Planning app: 3/2022/1039

113 Kemple View

I am writing to express my concerns about the proposed development adjacent to 115 Kemple View.

1 PROPOSED SITE PLAN 1
1 : 200

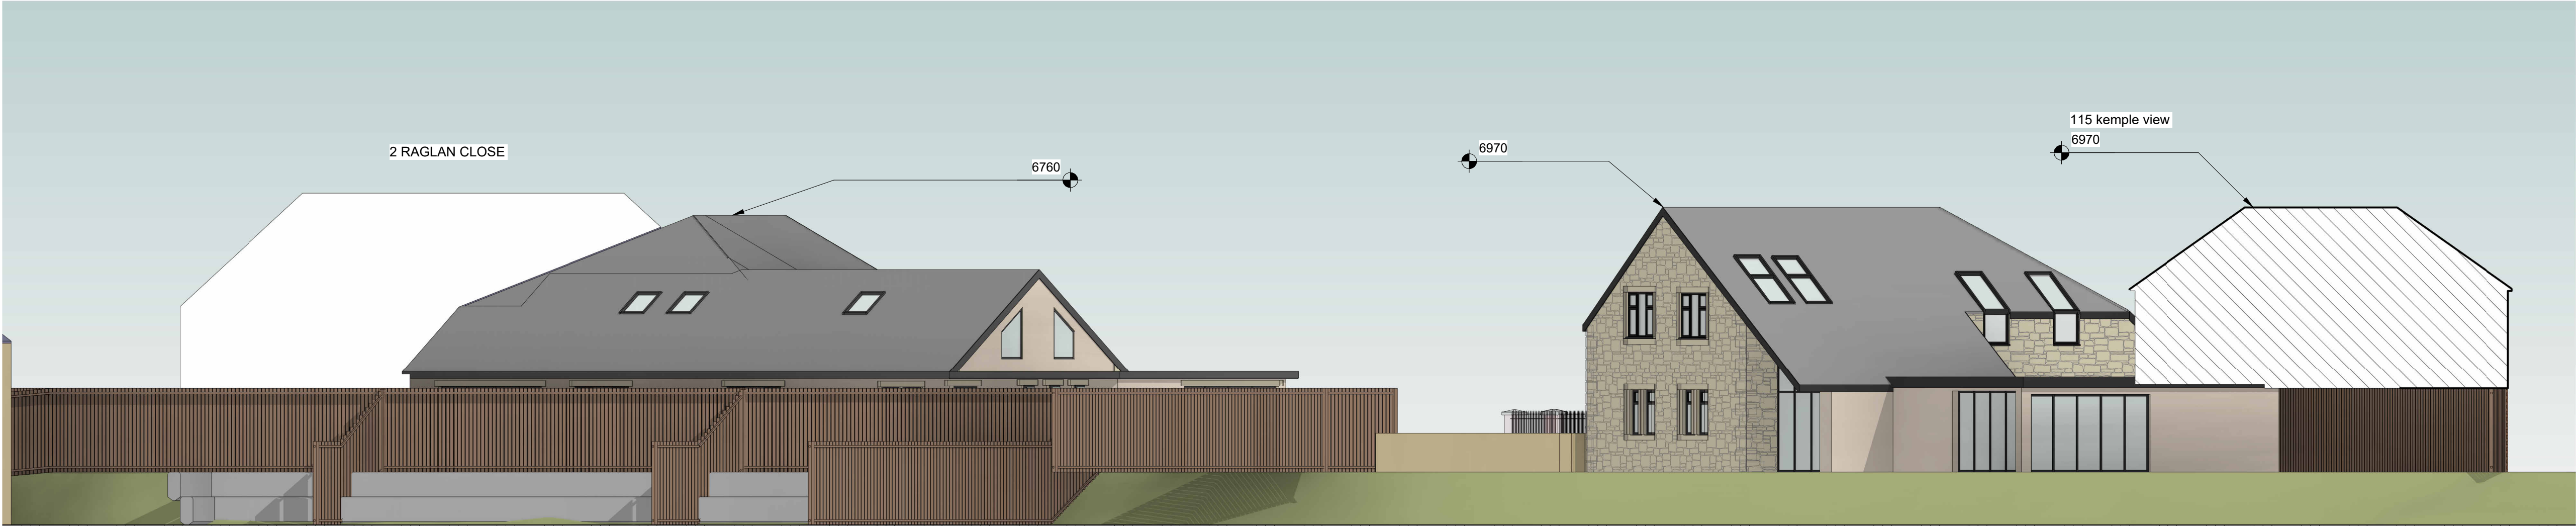
This is the fourth time that planning has been applied for and i cannot see a great deal of difference between the latest plan and the previous one. My concerns were lack of garden on the previous application for 2 very large detached family homes. However there are now two small grass areas. The rest of the plot is car parking for 8 cars and a large gravel area. My concerns are that the houses are much larger than the adjacent 2 sites. Storey actually took note of local concerns mainly from the row of bungalows on Kenilworth Drive and they built bungalows and dormer bungalows so as not to take light from the existing properties. The proposed detached houses are larger than the surrounding properties and their boundaries are very close with very little garden space behind them. Consequently i am concerned that this application looks more suited for offices or meeting places. I would be reassured if you could confirm that they are only to be used as residential properties and will at no point be permitted to change their use.

This leads to my major concern about access to the proposed site. There are no plans at all which show how these properties will be accessed from the main road. The entrance is very limited and [REDACTED] owns part of the entrance as the gates took some of [REDACTED] space. Even as it is now [REDACTED]

[REDACTED] This is dangerous, especially when [REDACTED]
[REDACTED] I should also like reassurances that it will not be used for cars to drive over. What was once a quiet cul de sac with a maximum of 2 cars driving in, it could now reach 10 cars. Also the construction vehicles and lorries will have to reverse out as there is limited turning space. Neighbours often overspill on the road so again, space is limited and the builders will be reversing onto a blind bend with a local bus route twice an hour. I hope that this will again be investigated by the Highways Agency.

I would appreciate it if you could add the area outside [REDACTED] and the width of the entrance/exit route to the plans as
